Re: Objection to Development Application SSD 16_7919 – 85 Carabella Street, Kirribilli

TRANPLAN Consulting has been engaged by the local residents of 111 Carabella Street, Kirribilli to consider & respond to the Department on their behalf in respect of Development Application **SSD 16_7919** at **85 Carabella Street, Kirribilli** for the **Staged development application for a concept proposal for the redevelopment of the Loreto school campus in the south and east precincts, with detailed approval sought for works in the western precinct, as well as the vertical connectors and landscaping across the campus** (the development).

W21 Bedroom

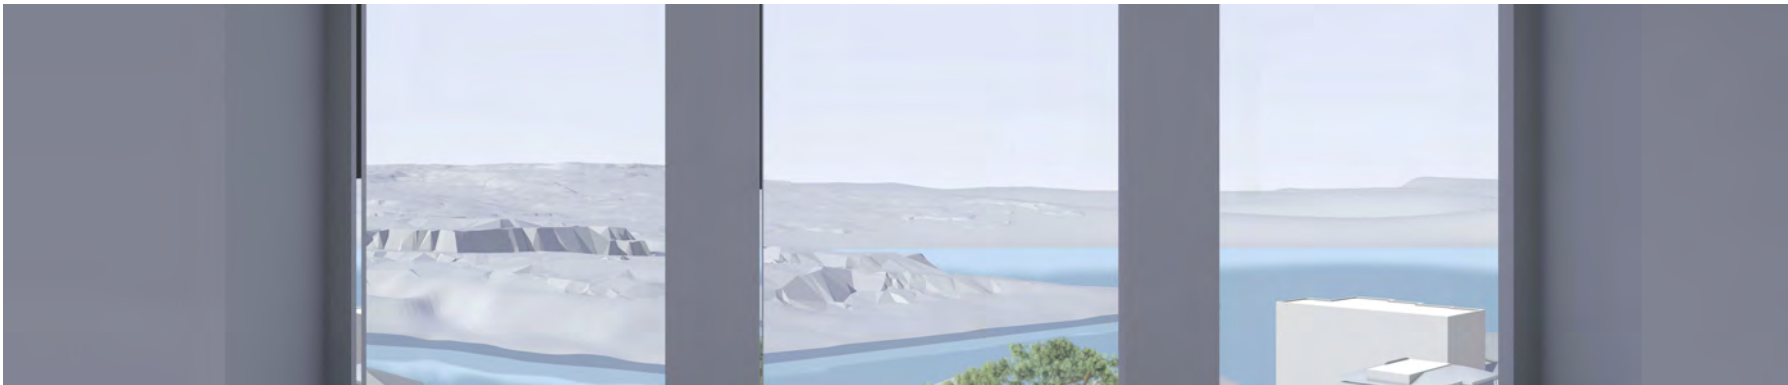
Figure 1 – Before & After from W21 on View Analysis plans*

*Note the significant impact of the non-compliant proposal; about a 50% reduction of views

*Note 2: The impact of the proposal to the 2 apartments above i.e. W21 & 22 is similar; about a 50% reduction of views, but is due to the non-compliance. Refer to Figure 3 below.

Figure 3 – Before & After from W21 & W22 on View Analysis plans

W23 Bedroom

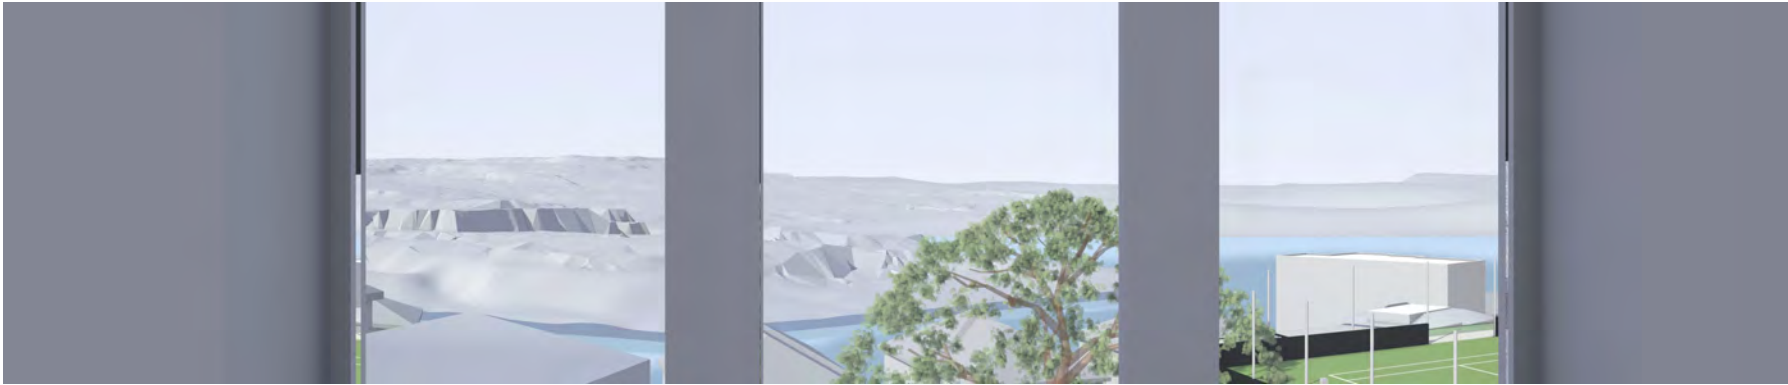
Picture 4 – Existing view of the harbour, forests & sky from inside the bedroom room (Ref W23 on View Analysis plans)

Figure 2 – Before & After from W23 on View Analysis plans*

*Note 1: The significant impact of the proposal (compliant or not); about a 50% reduction of views.

Concept Proposal Envelope Elevation

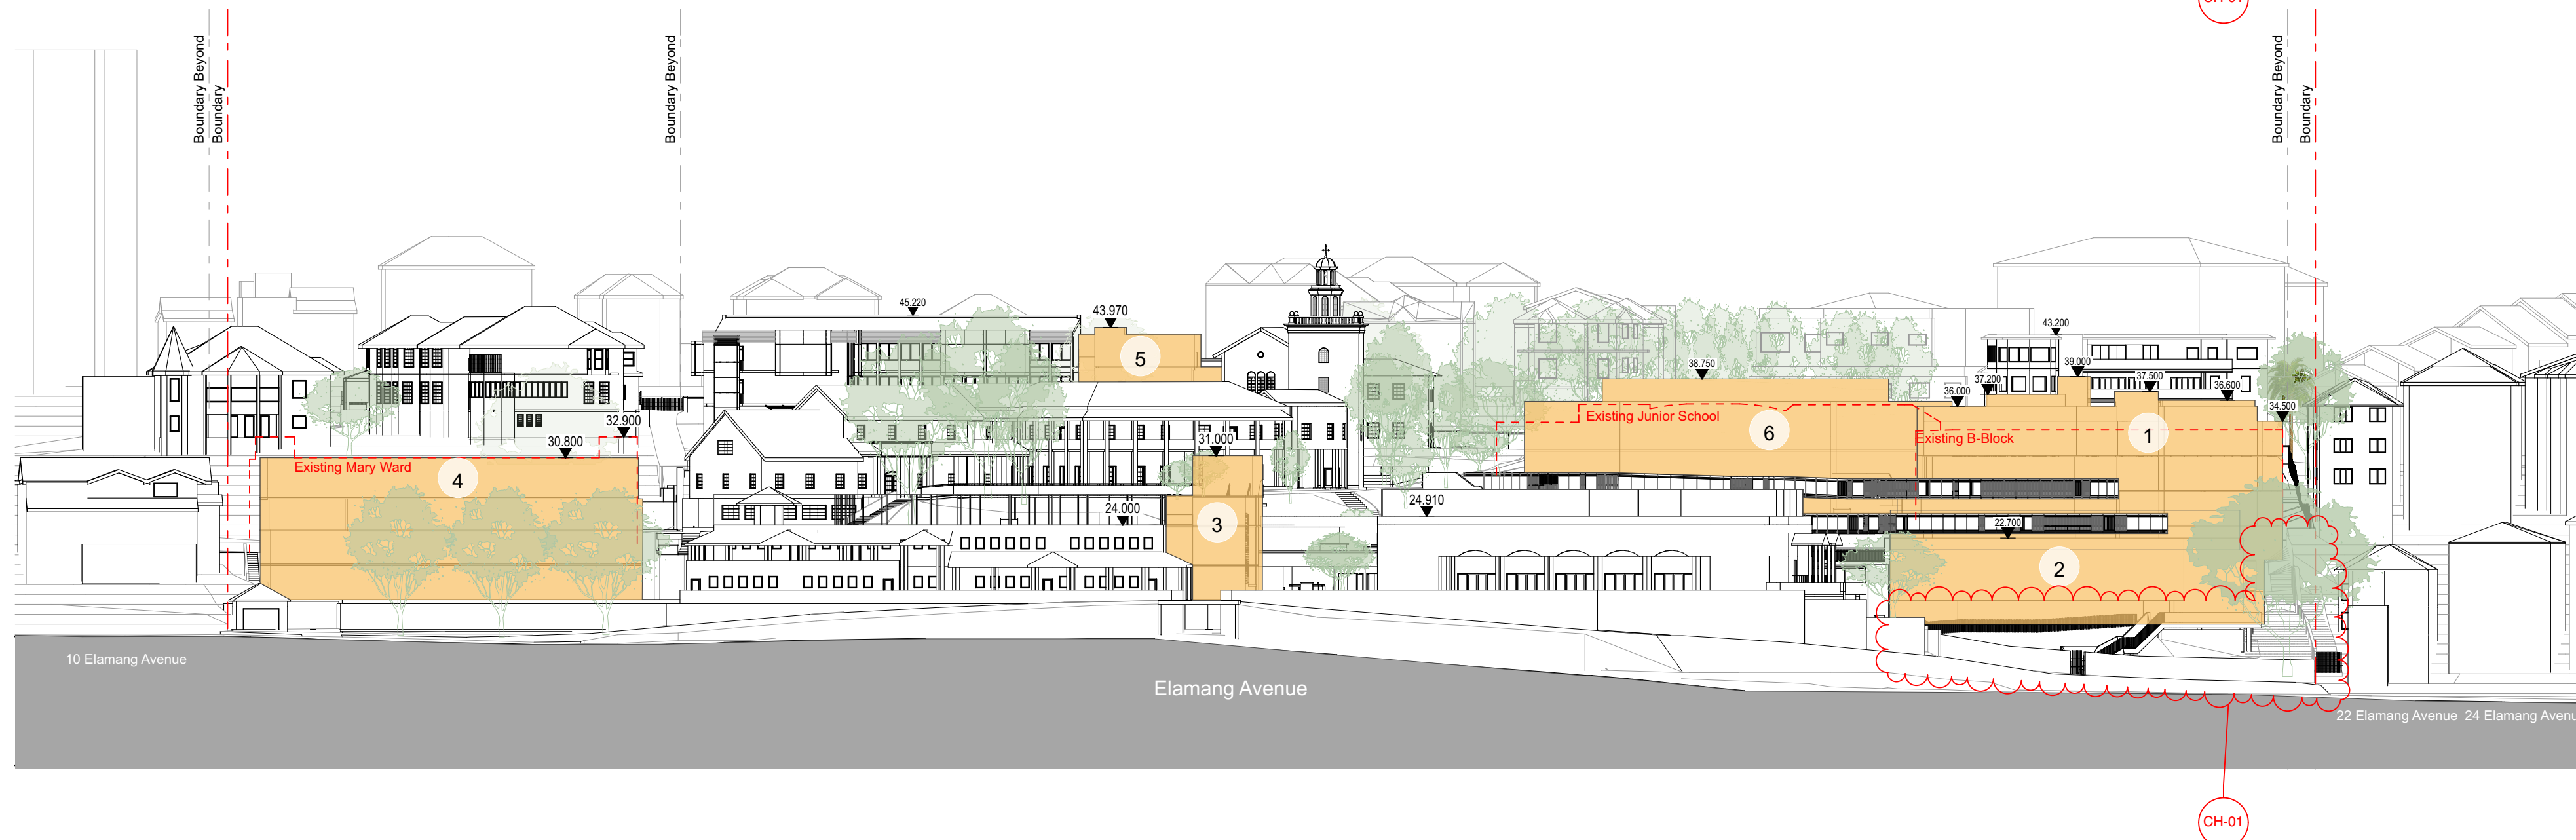
LEP 2013 sets a maximum height of 12m for the land zoned R4 High Density Residential. The proposed new Learning Hub on the “Western Precinct” (separated/setback from the common boundary with the existing residential apartment at 111 Carabella Street, Kirribilli by only approximately 3.14m) proposes a maximum height of RL 37.50 (14.5m); 2.5m above the 12m height limit which applies to this part of the campus.

The Learning Hub does not comply with the side setback and building height plane (of 45 degrees inwards starting at 3.5m from NGL) DCP controls for the R4 High Density Residential zone and will have significant amenity impacts to the residents of 111 Carabella Street, Kirribilli in terms of loss of privacy, views, ventilation and daylight.

However, the new Learning Hub proposes a maximum height of RL 37.50 (14.5m) exceeding the maximum height by 2.5m; maximum height of 12m applies to this part of the campus (land zoned R4 High Density Residential).
